Padstow Resource Recovery Facility (SSD-10450)
Request for additional information

I refer to Response to Submissions for the Padstow Resource Recovery Facility (SSD-10450). The Department has reviewed the information and notes that there are still matters to be addressed.

Figure 3-1: Site Water Balance Diagram

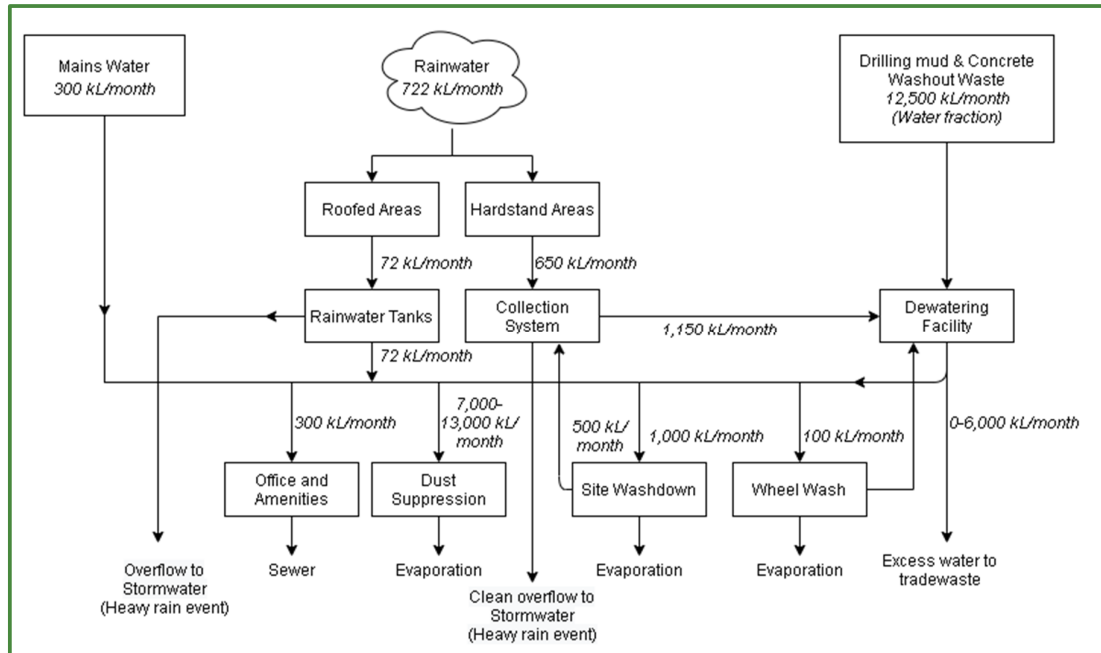
- Characterise water quality at point of discharge in accordance with the SEARs.
- The water balance shows that 650 kilolitres (kL) per month of leachate in the collection system from the hardstand areas. The water balance also shows that 1,150 KL/month would be sent to the dewatering facility from the hardstand. Further clarification on the discrepancy is required.
- Water from operations such as dust suppression and site washdown do not appear to be accounted for in the water balance inputs. You are requested to update the water balance or clarify why these activities have not been included.

PROJECT		PROPOSED RESOURCE RECOVERY 81-87 GOW STREET PADSTOW LOT A DP103140		PROJECT NO. 1730	
CLIENT		GOV STREET RECYCLING PTY LTD		SCALE 1:250	
TITLE		PROPOSED SITE PLAN		SHEET NO./ISSUE A02 C

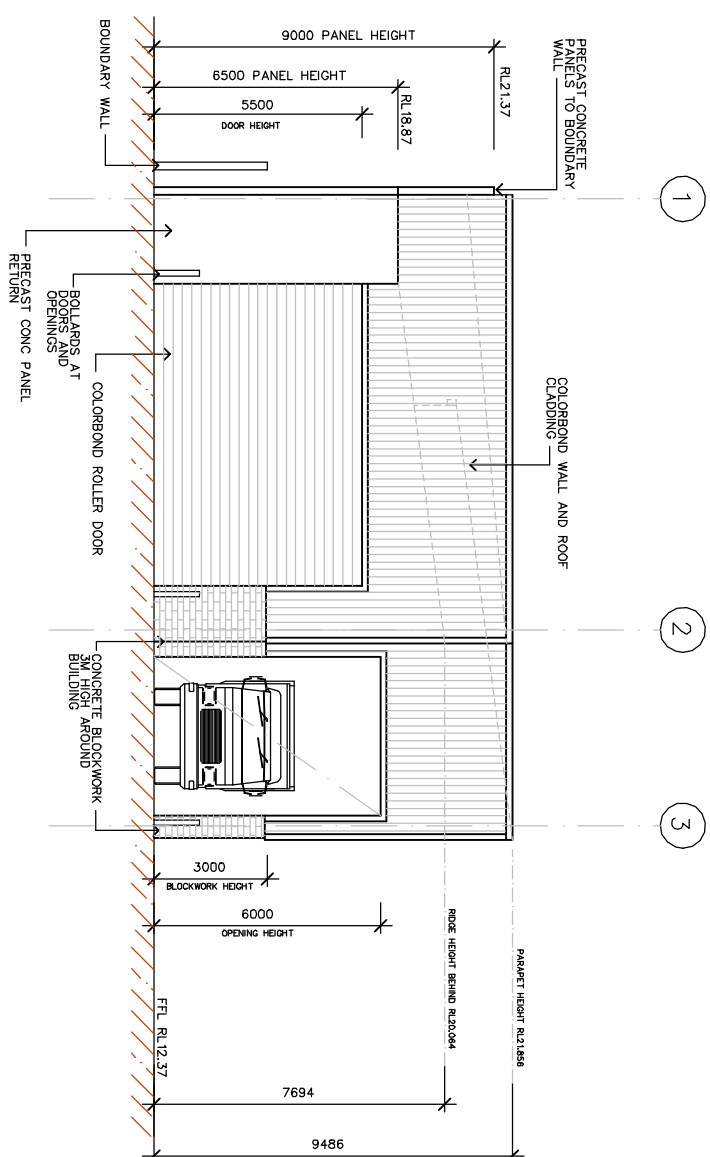
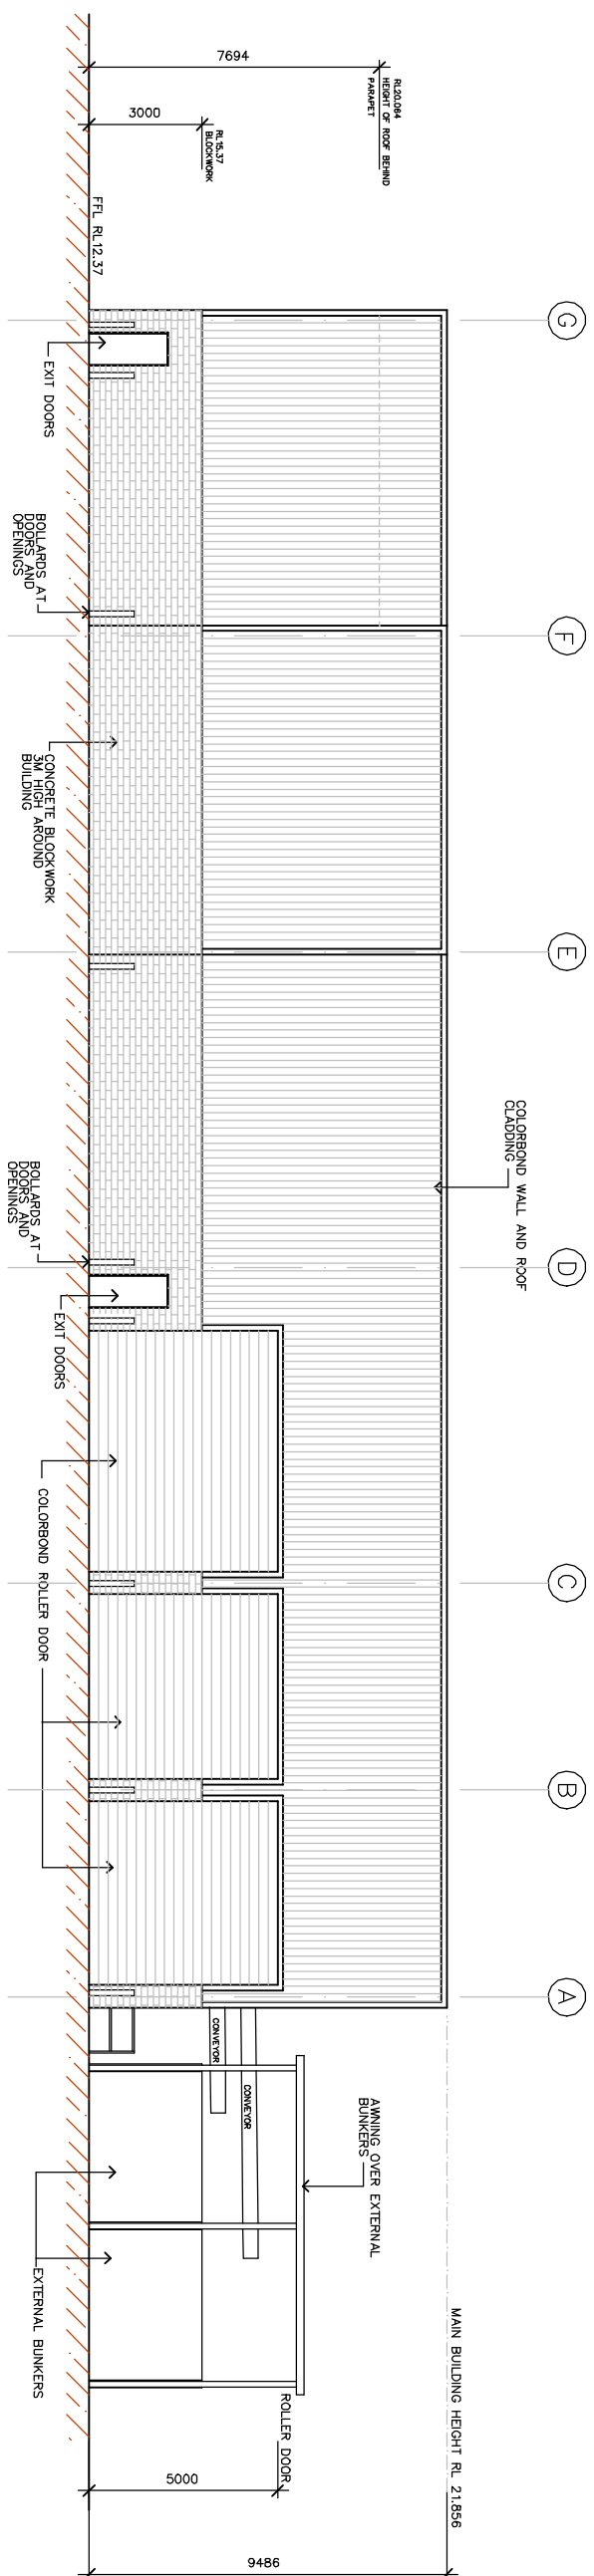
- Clarification on which swept path analysis plans are still applicable is required.
- Provide swept path analysis for all trucks shown on Plan A02D in the Traffic Impact Assessment.

- Provide a swept path analysis showing trucks leaving the unloading bay while another truck is queuing adjacent to the dewatering facility as per drawing A02D.

RIGID TRUCK QUEUING PLAN

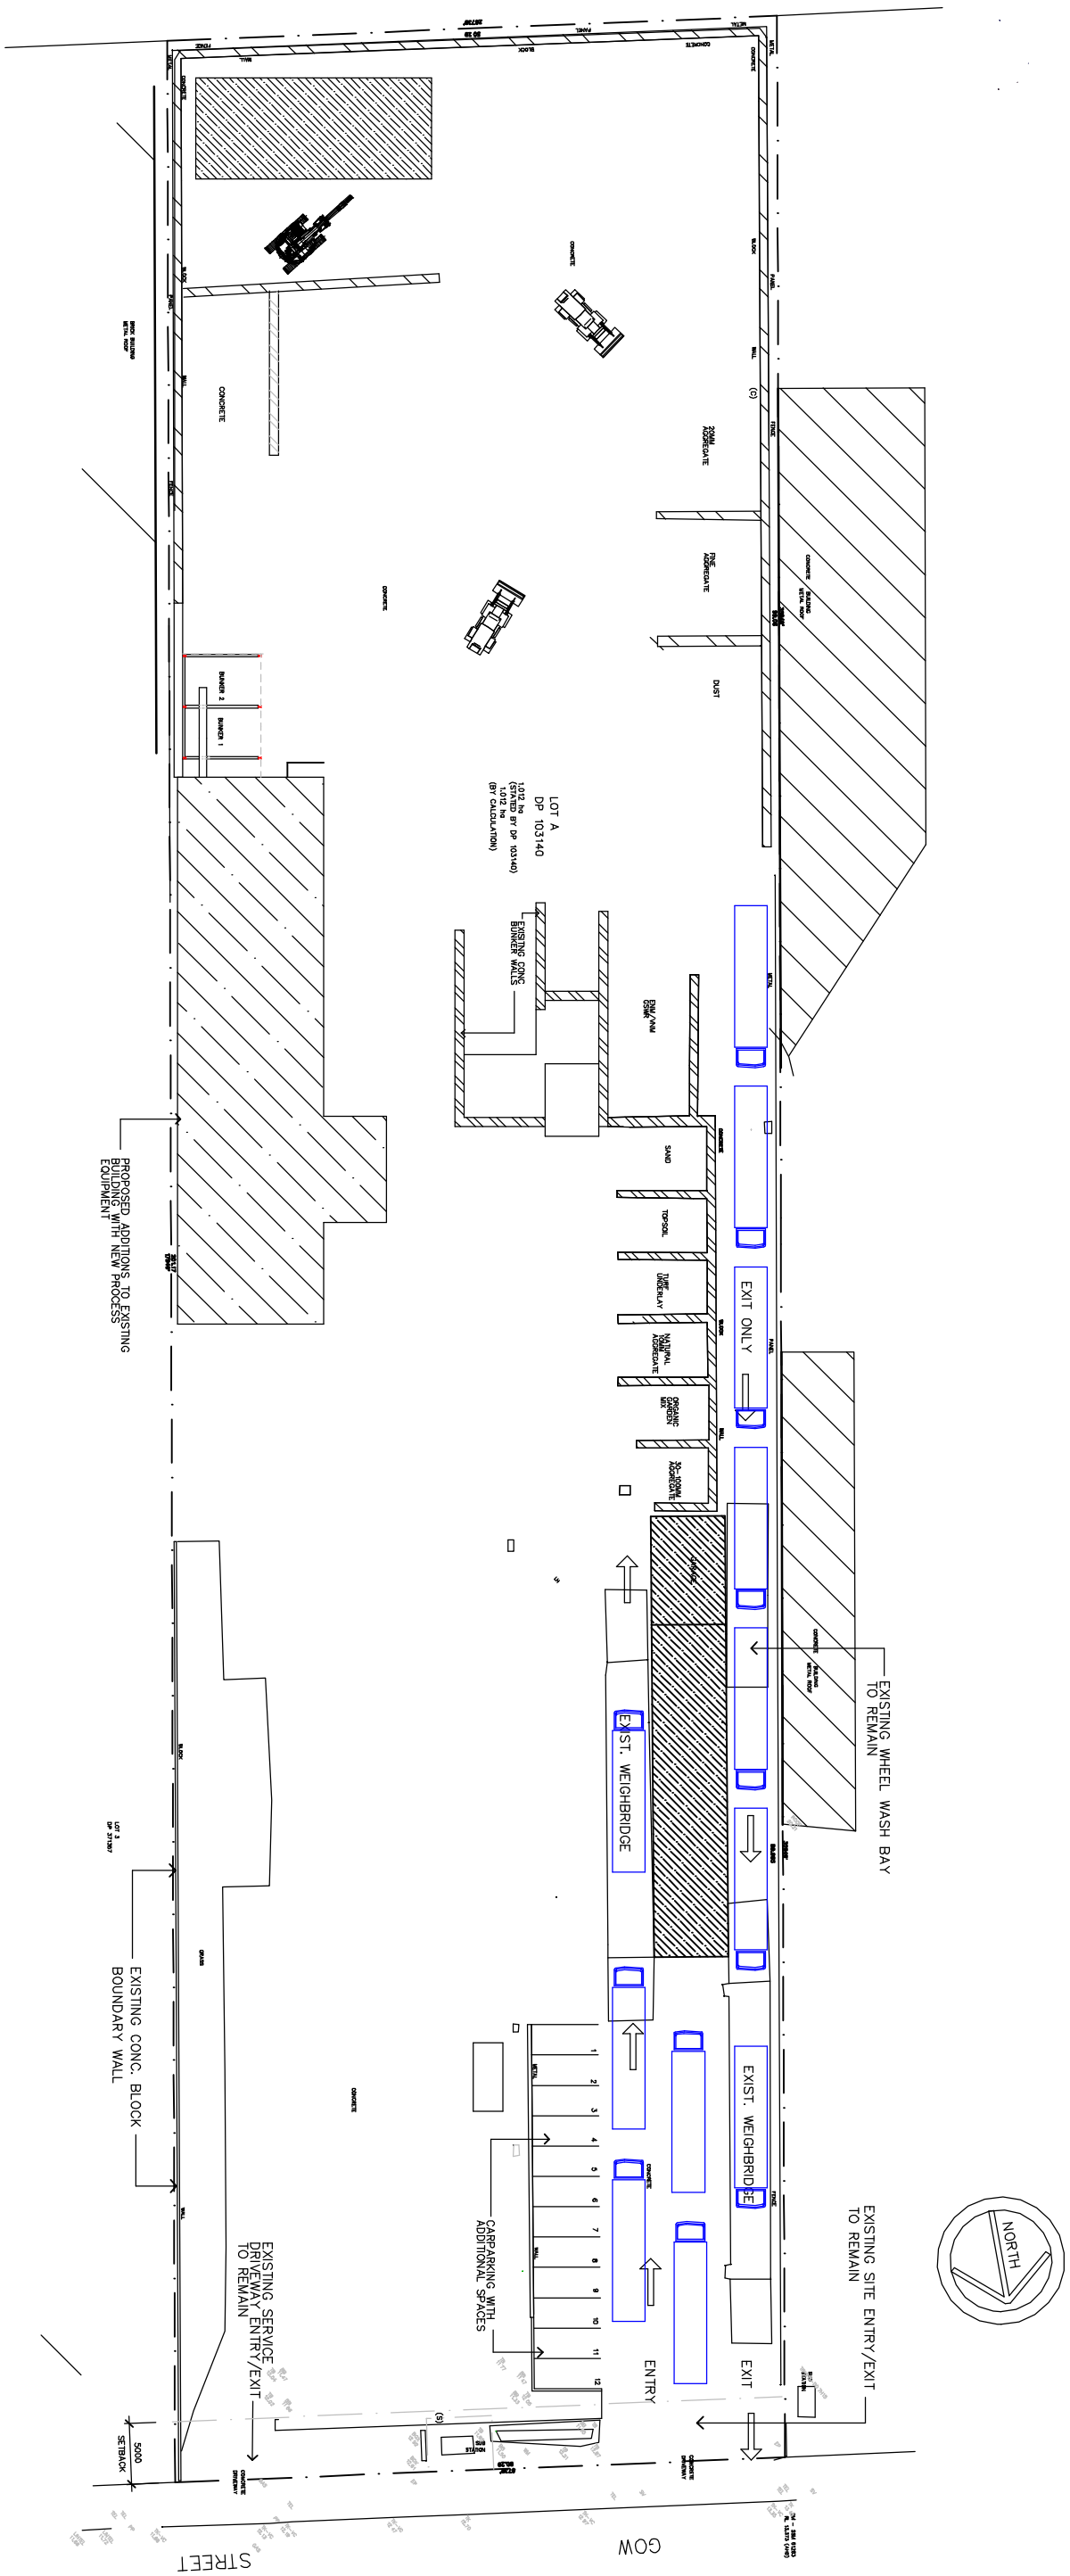
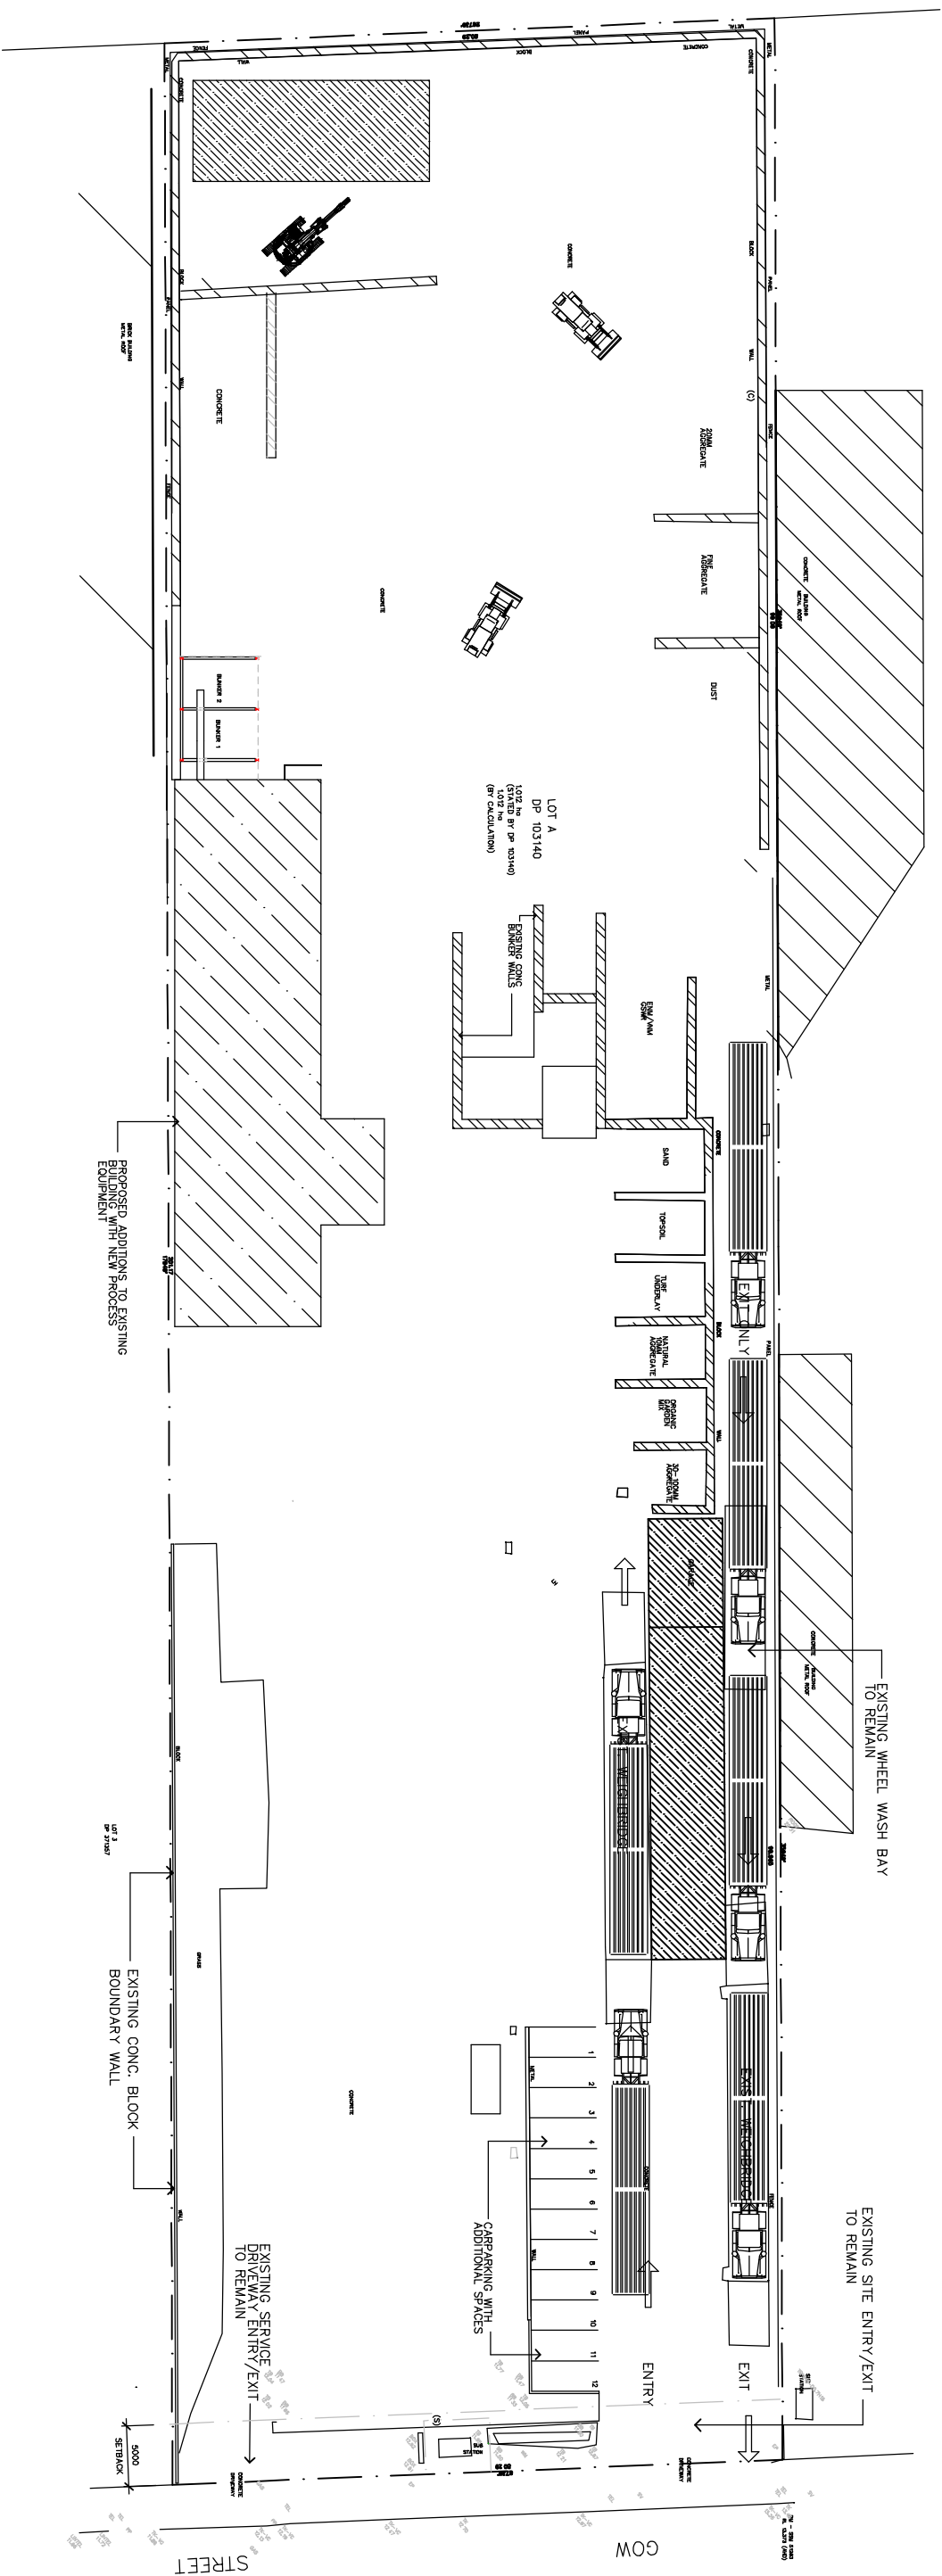
- Clearly describe queuing requirements on site based on the facility's peak hour and expected unloading and loading times.
- The queueing spots appear to have been changed from those shown in the EIS. These changes must be clearly described in the RTS.

- Provide the expected heavy vehicle trip distribution and describe the proposed vehicle routes.
- It is unclear whether service vehicles can access the site while heavy vehicles are queuing. A swept path showing both queuing vehicles and the service vehicle path is required. Alternatively, explain how service vehicles would access the site.

TRUCK LOADING, UNLOADING AND WAITING PLAN

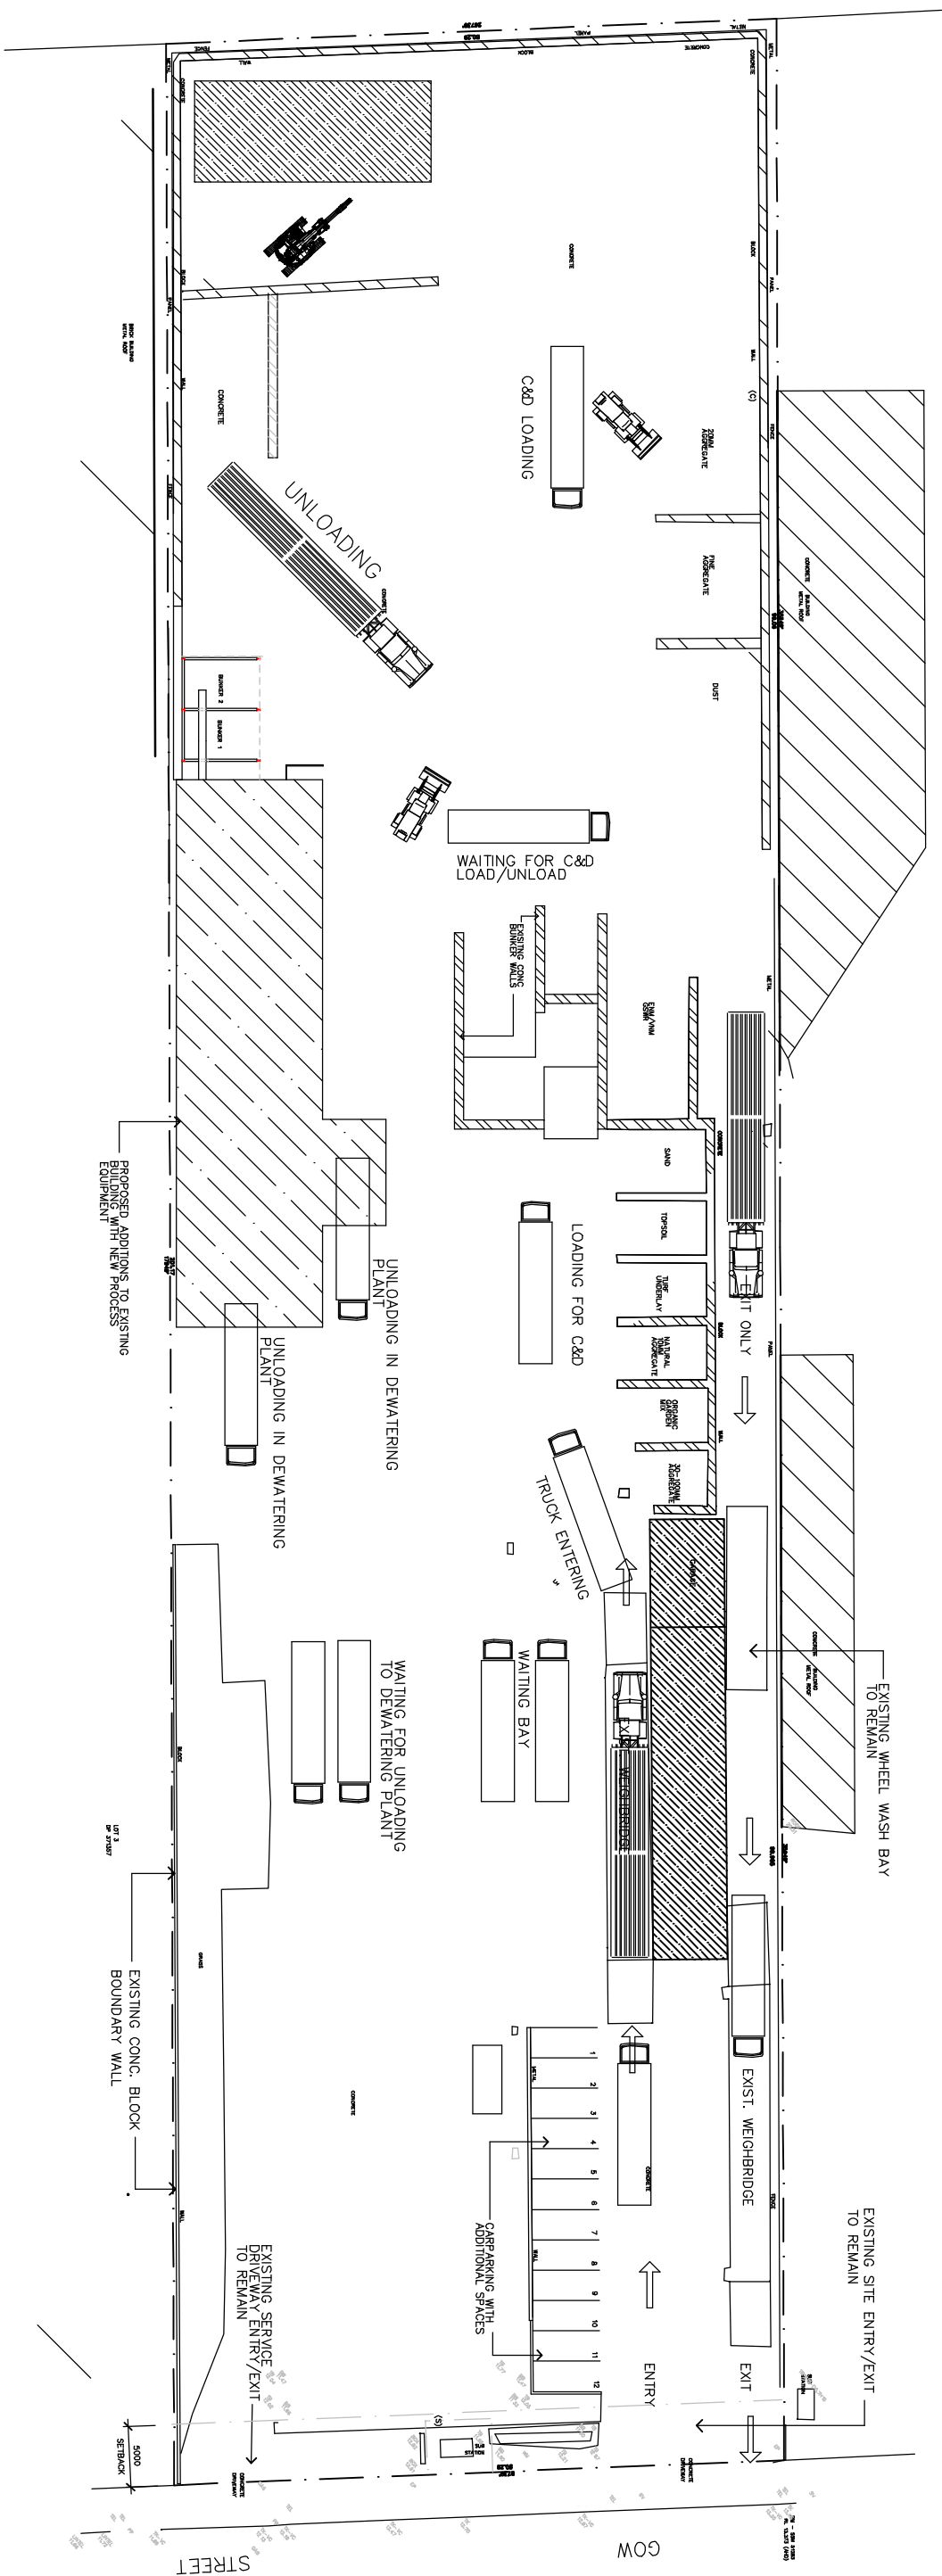
- It is unclear where in the architectural plan set the revised plans are located. You are requested to clearly label the revised plans.
- The unloading and dewatering plant drawing A10 included in the Environmental Impact Statement (EIS) shows heavy vehicles backed into the dewatering plant in two locations. However, the revised swept path drawings (particularly A02) show heavy vehicles unloading in a different location. Clarification is sought on how and where unloading/loading would occur and whether trucks would need to reverse into the building.
